CITY OF ALBUQUERQUE

December 12, 2017

**Re: Galles Chevrolet
2801 University Blvd
30-Day Temporary Certificate of Occupancy- Transportation Development
Transportation Development Final Inspection
Engineer's/Architect's Stamp dated X11-13-17 (H15-D065)
Certification dated 12-06-17**

A3 TYP. H.C. PARKING SIGN
SCALE: NTS

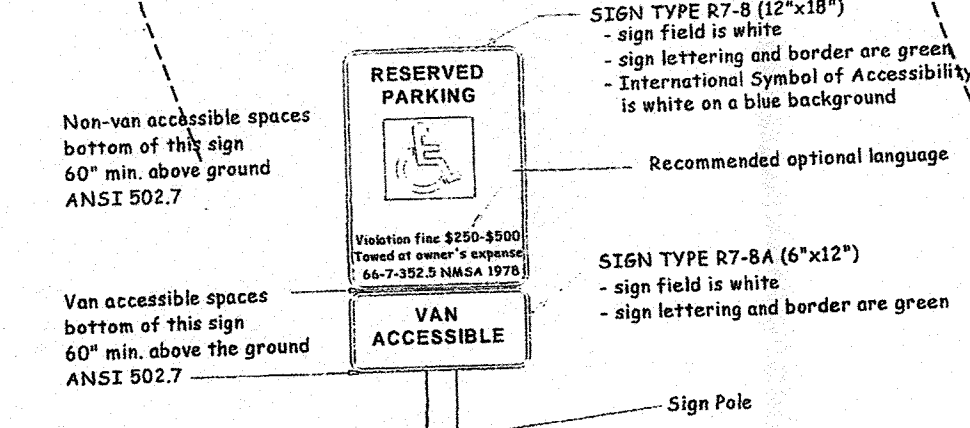
1. The ADA accessible parking sign must have the required language per 66-7-352.4C NMSA 1978 **"Violators Are Subject to a Fine and/or Towing."** Please update the signs and provide a picture for the permanent CO.
